Subject: Fwd: FW: Strategic Planning Response Re-consultation CM/7/17

At our meeting Council agreed to urgently raise concerns about the highways recommendations on lowering a wall and removing vegetation to allow for visibility splays re CM/7/17. This materially affects the planning application we originally made no objection to.

1703/SK2
1.12.16
RCA

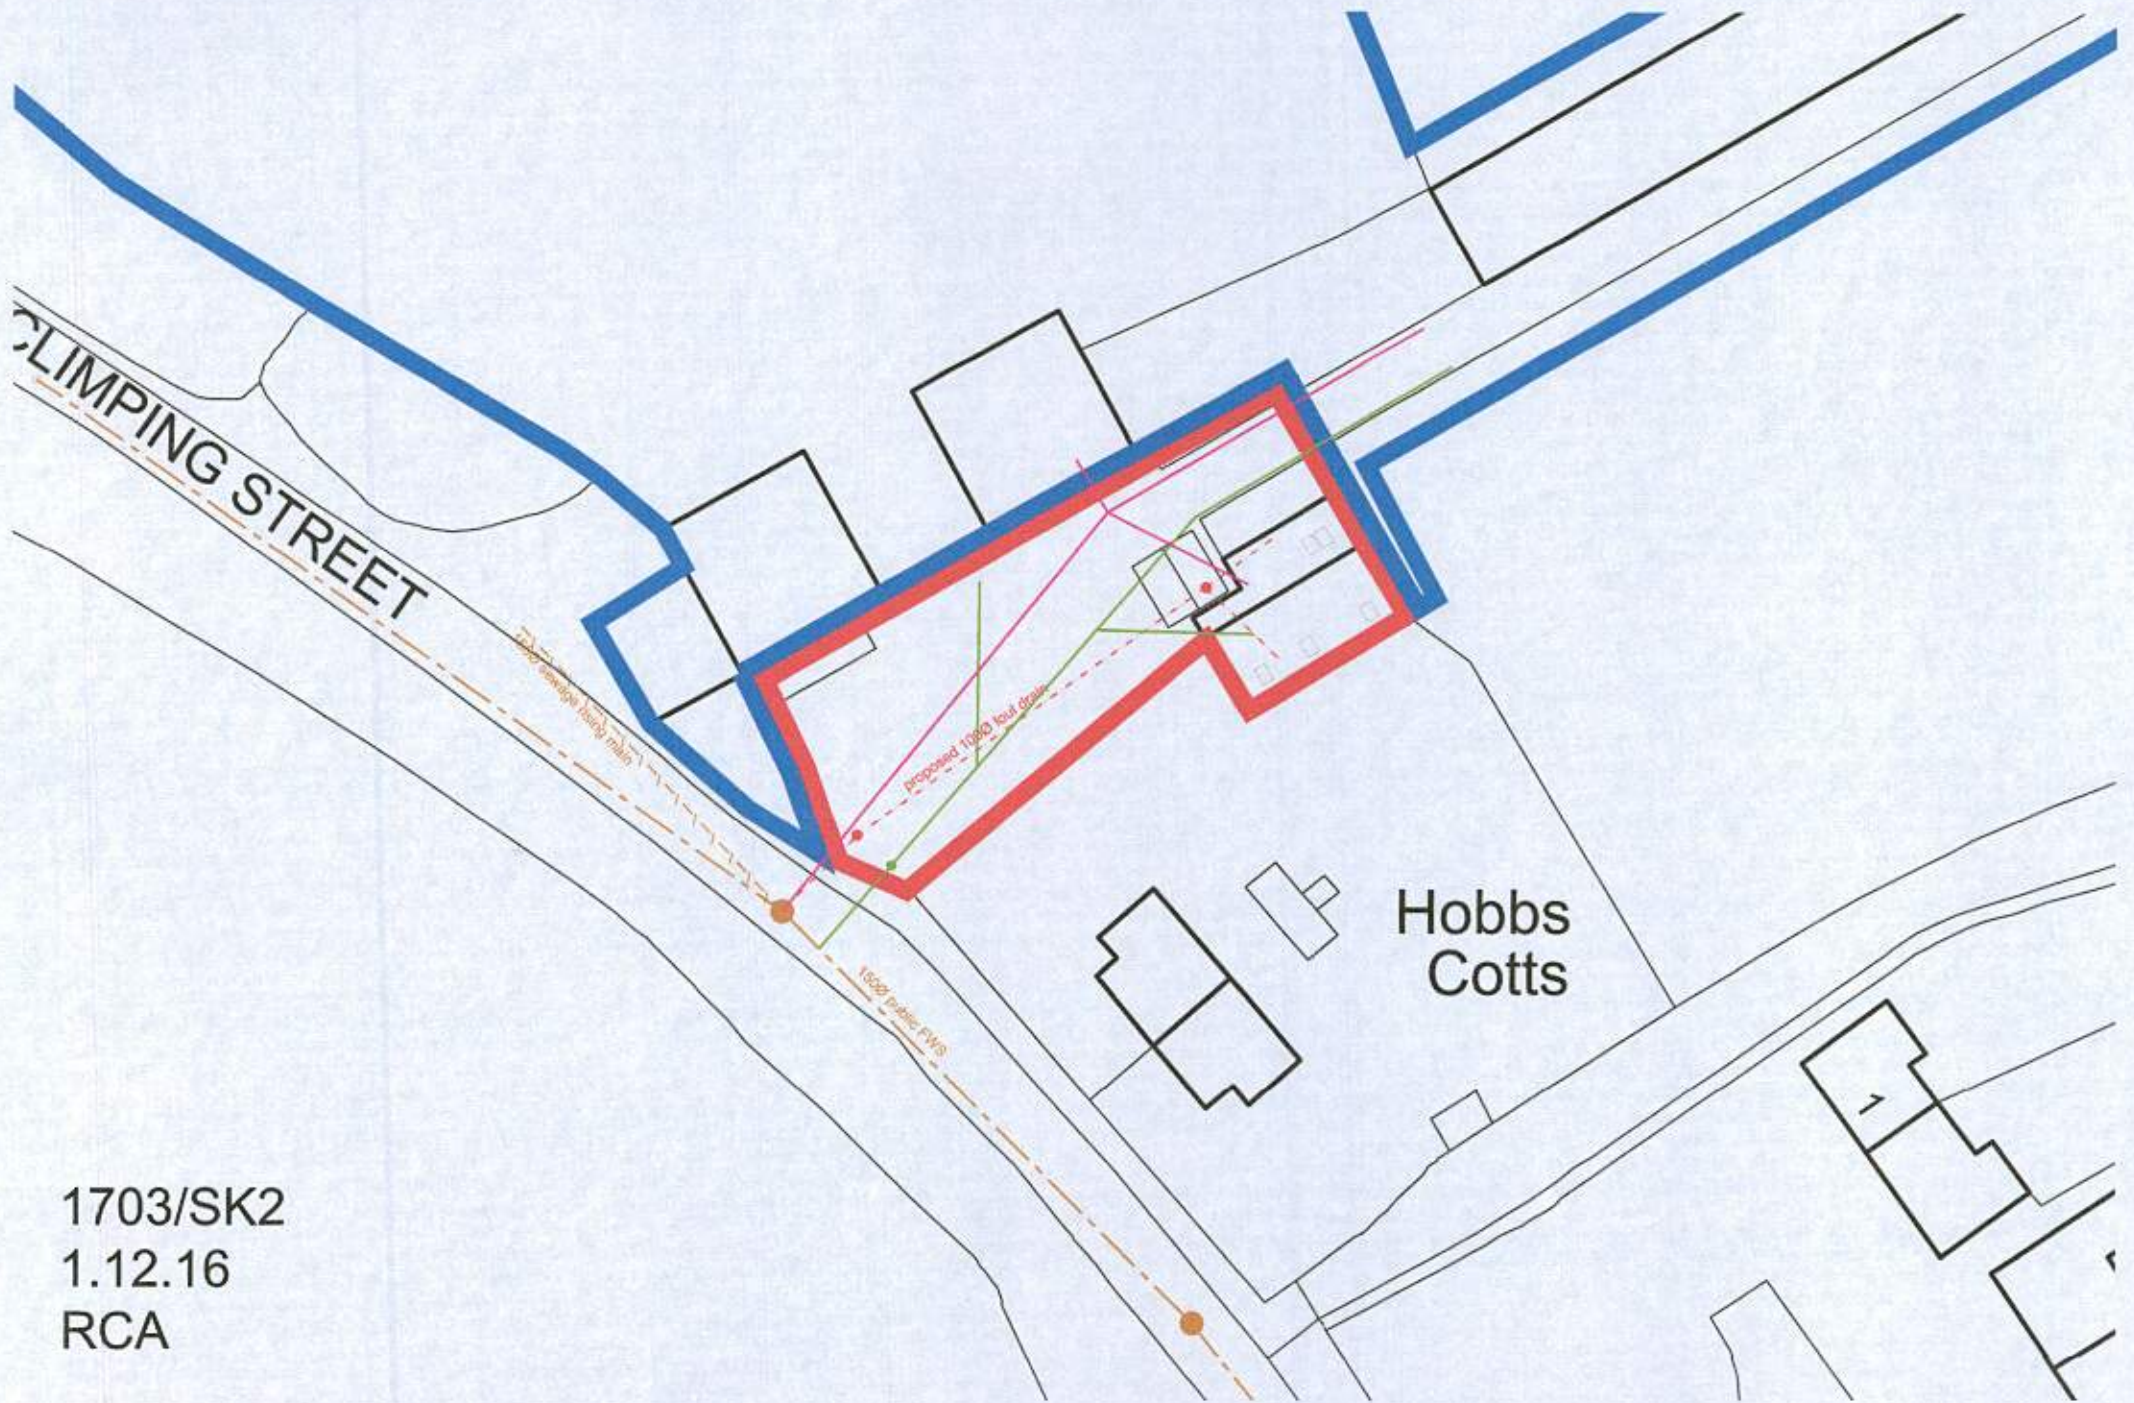
Council is particularly concerned that the flint walls should not be removed or damaged and that the well established tree which is set back from the road should be retained.

There is a newer concrete faced/brick wall to the southern boundary of The Pound which Council would have less objection to a slight lowering to match the height of the flint wall to the west boundary but we see no necessity for this to be required as other properties in Clymping Street have similar access arrangements.
